Case Officer: Caroline Ford

Recommendation: Approval

Applicant: London and Regional Properties

Proposal: Foul water tank and pumping station compound and enclosure to serve approved hotel

Drawing Title  
PROPOSED SITE LOCATION PLAN/BOUNDARY ILLSTRATING FOUL WATER PUMPING STATION

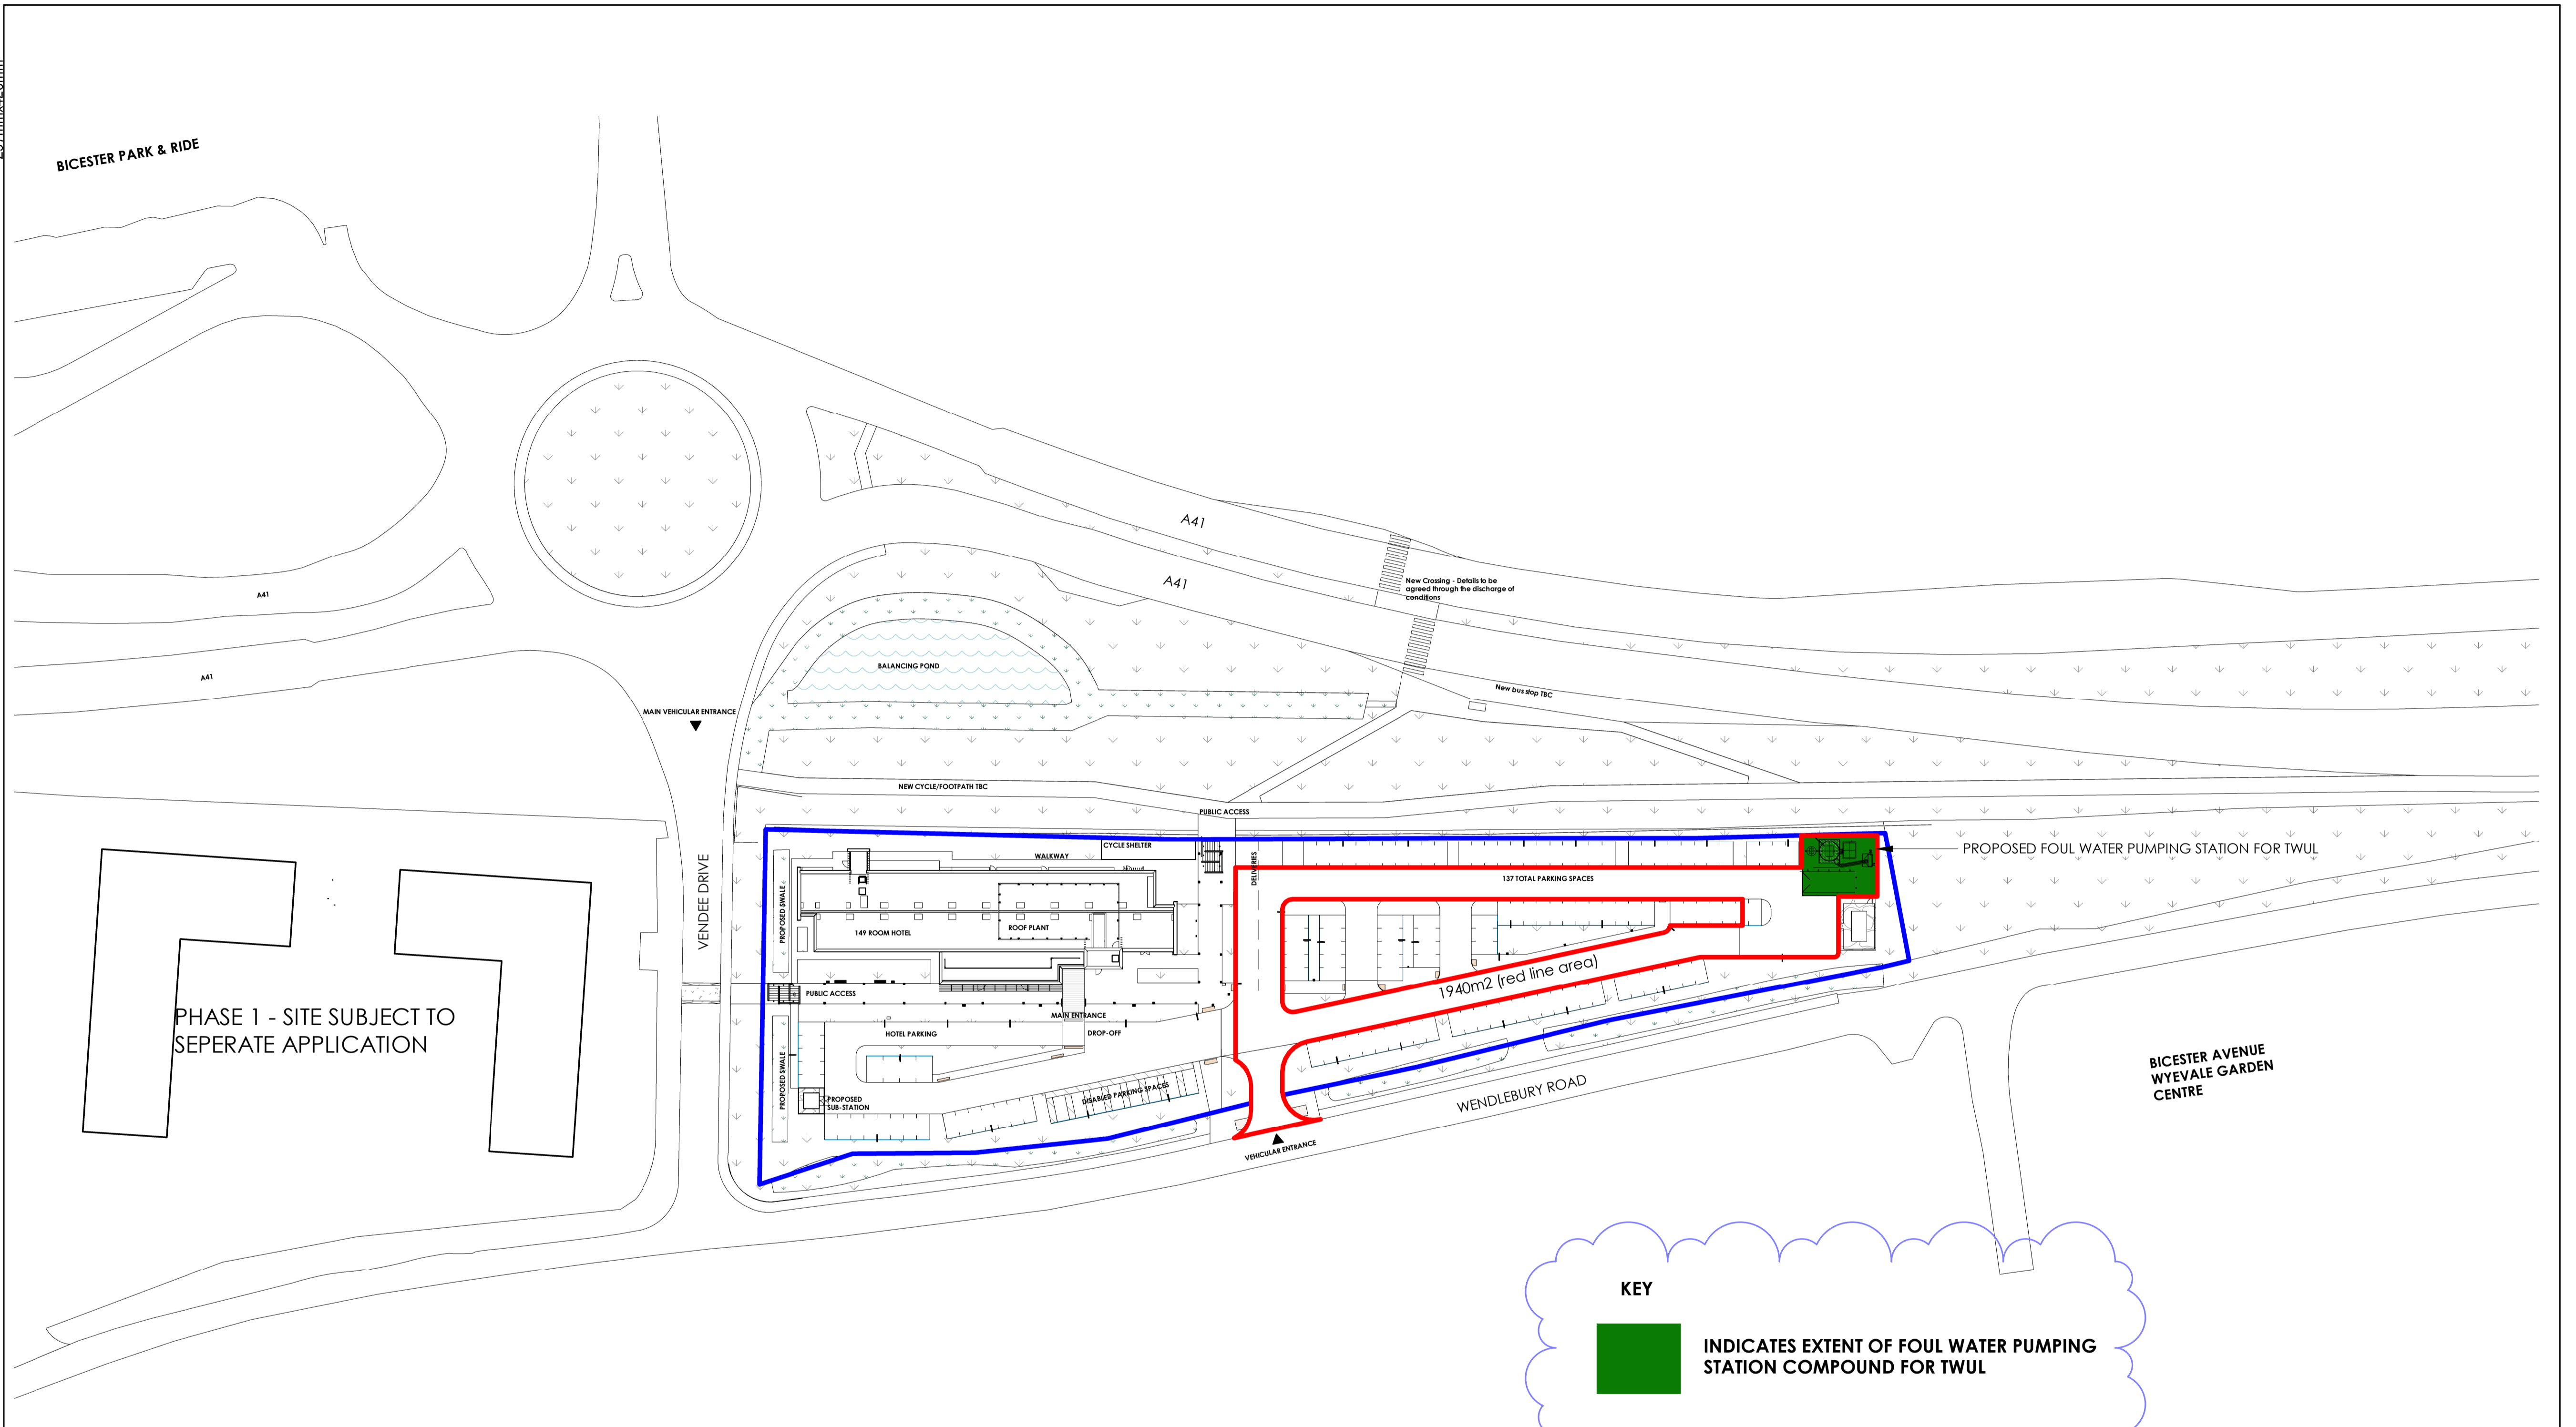
- 6.8. OCC HIGHWAYS: **Object** on the grounds that the proposal is likely to have an adverse impact on the local highway network from a traffic and safety point of view. The main concern is the loss of the 7 car parking spaces, which, combined with the 5 previously lost gives a total of lost spaces of 12 meaning the originally approved 149 spaces would fall to 137. The following points are made:

- The applicant should explore other options including a reconsideration of the location of the foul water compound or if there is no other location for the infrastructure, other options for parking such as the garden centre.

- 8.19. On this basis, I consider that the 137 parking spaces remaining to serve the hotel is sufficient to provide a satisfactory level of parking and that this would not have an adverse impact on the local highway network. Whilst OCC do not agree with this, I do not consider this a matter that would be defensible at appeal if the application were to be refused based upon lack of parking.

**External Services Layout**

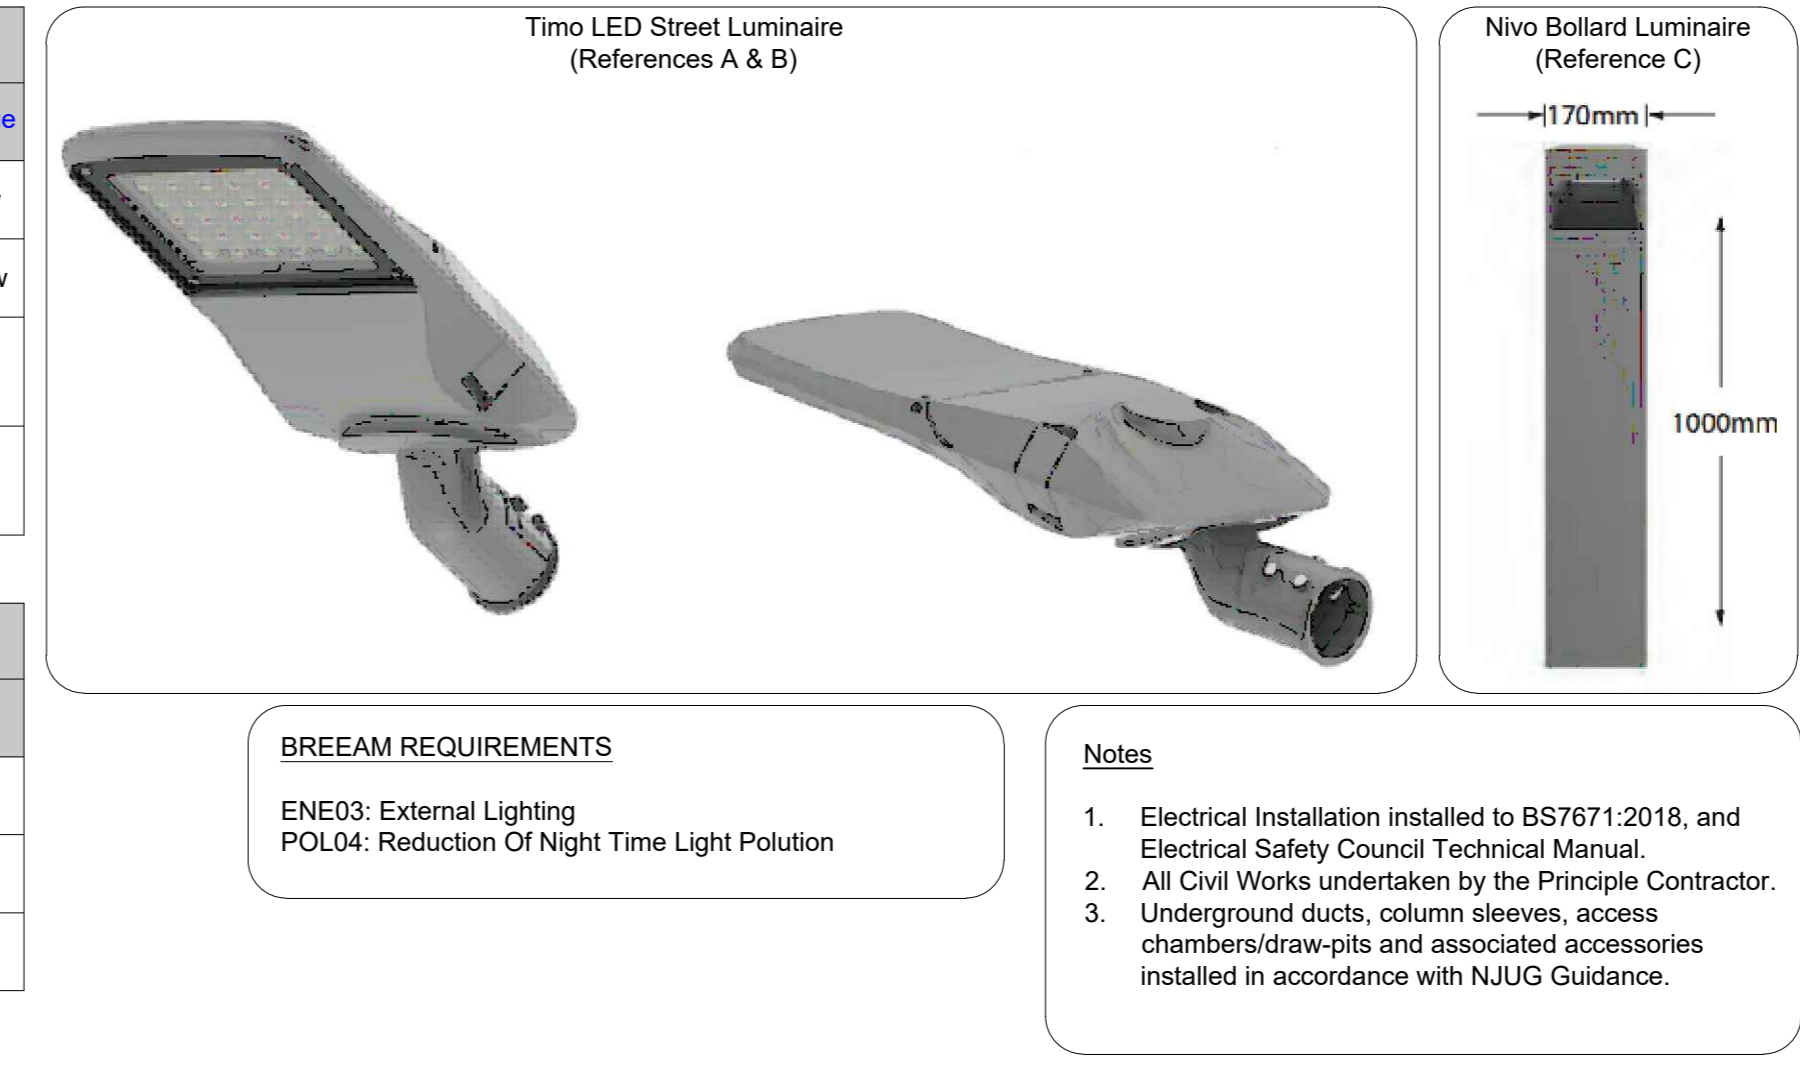
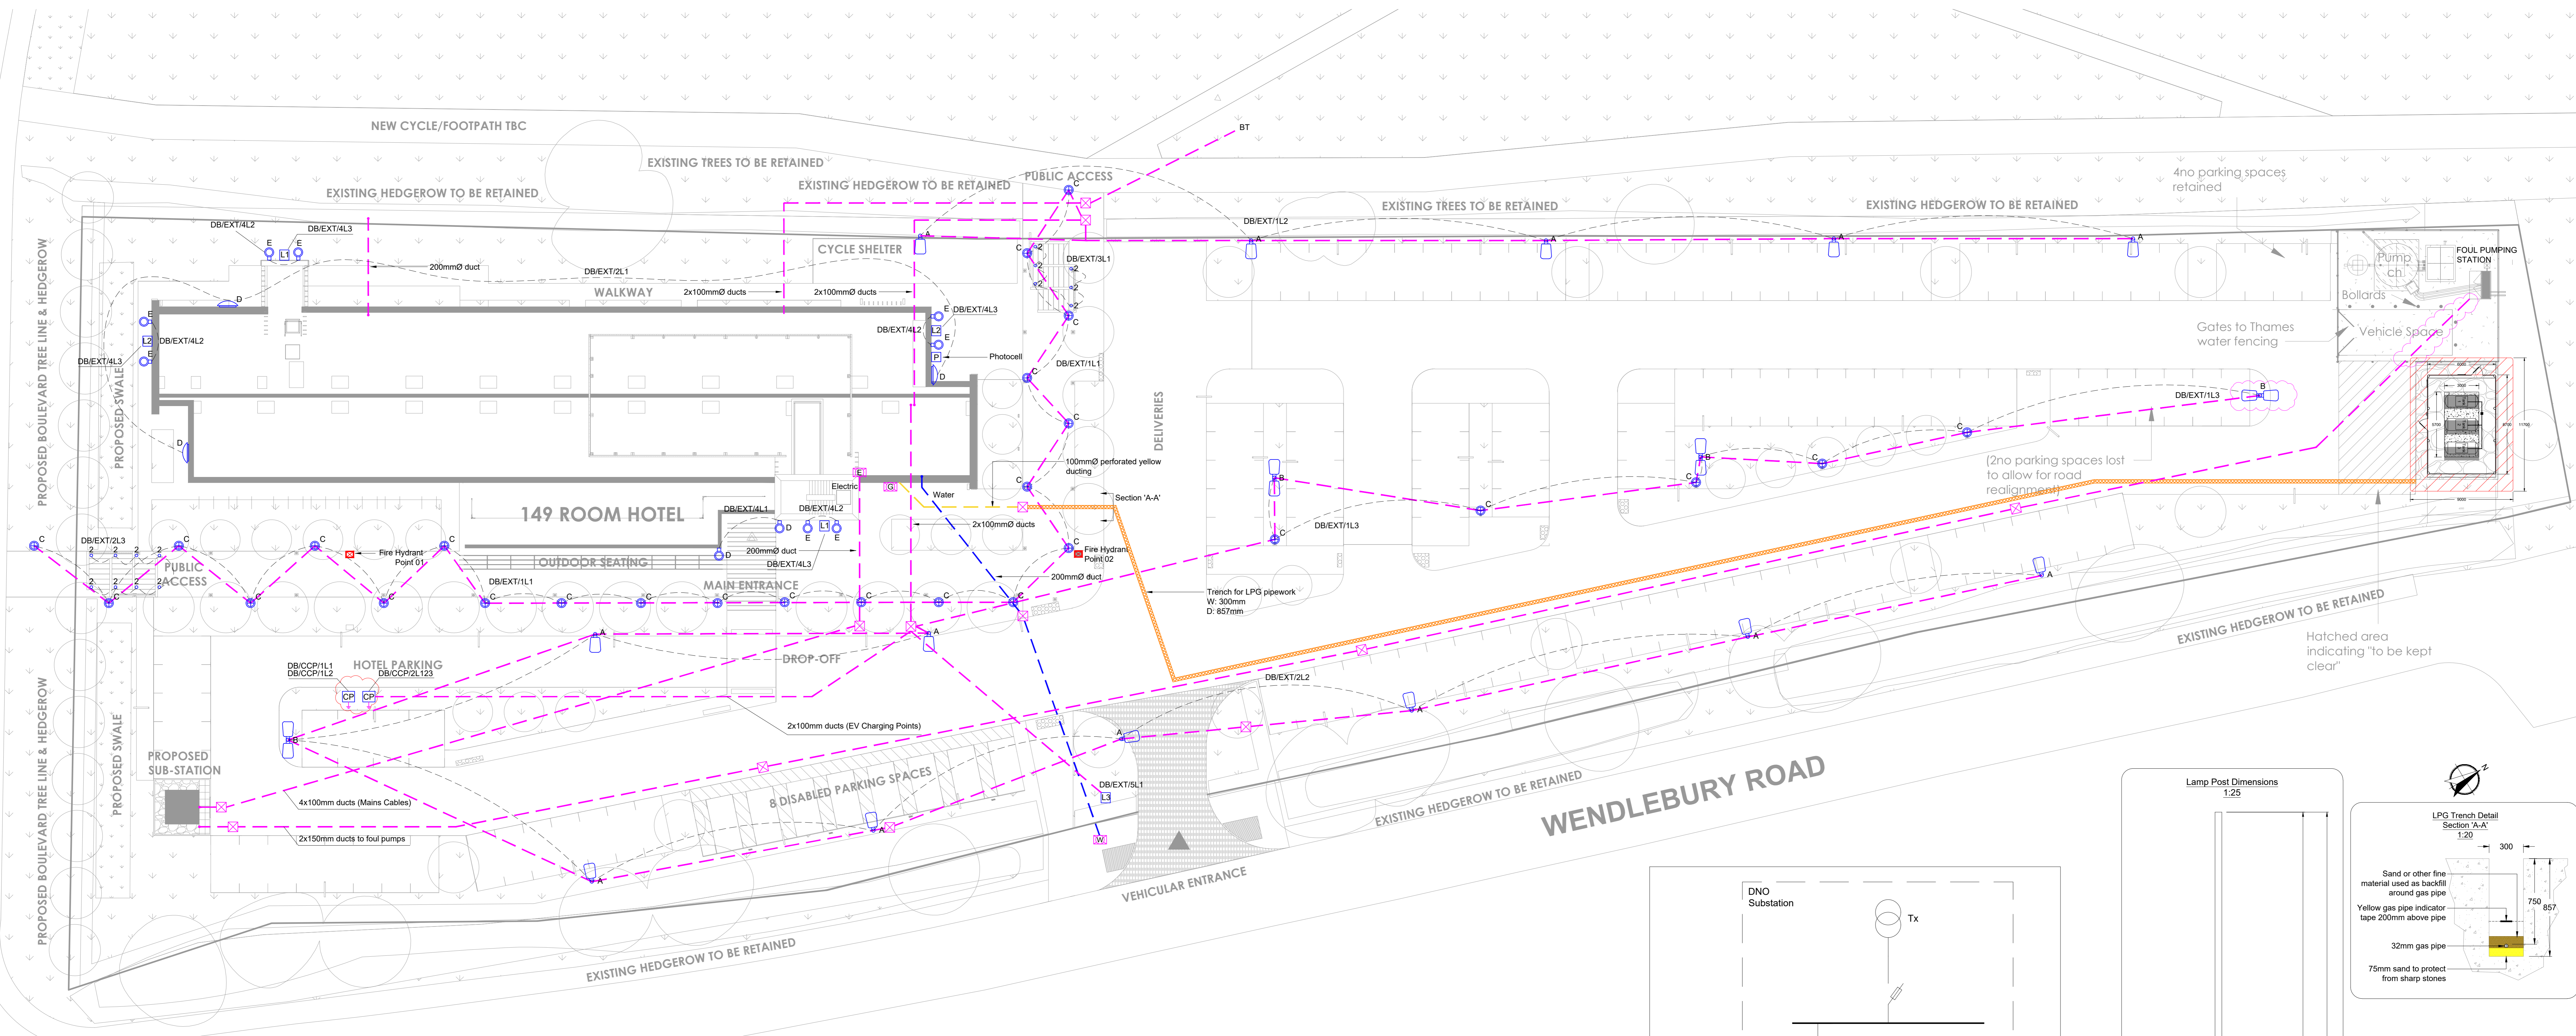
6.6. CDC ECOLOGY: Agreed with the comments of the Arboricultural Officer regarding the storing of the hedgerow for later re-instatement and agreed that additional information be provided. **Concern raised** regarding the positioning of some lighting columns to the west of the site which are within or adjacent to the existing hedgerow to be retained as they are likely to unavoidably cause an unacceptable amount of

light spill into the hedgerow if sited in that location. They should be sited further into the car park and their number reduced.

8.21. Service drawings have been provided and show how the new proposed infrastructure is served. One of the plans shows a lighting layout and this seems to show some amendments compared to the previous lighting plan approved as part of discharging a condition on the reserved matters consent for biodiversity enhancement measures. Whilst the Ecologist has raised some concern with the lighting shown adjacent to the western hedgerow, lighting has been approved along this boundary and also along the nearby 3m wide footway. As such, I am not convinced that what is shown is unacceptable.

8.22. Notwithstanding the above, the proposed lighting is outside the red line site boundary for this application and so cannot be approved under this application in any event.
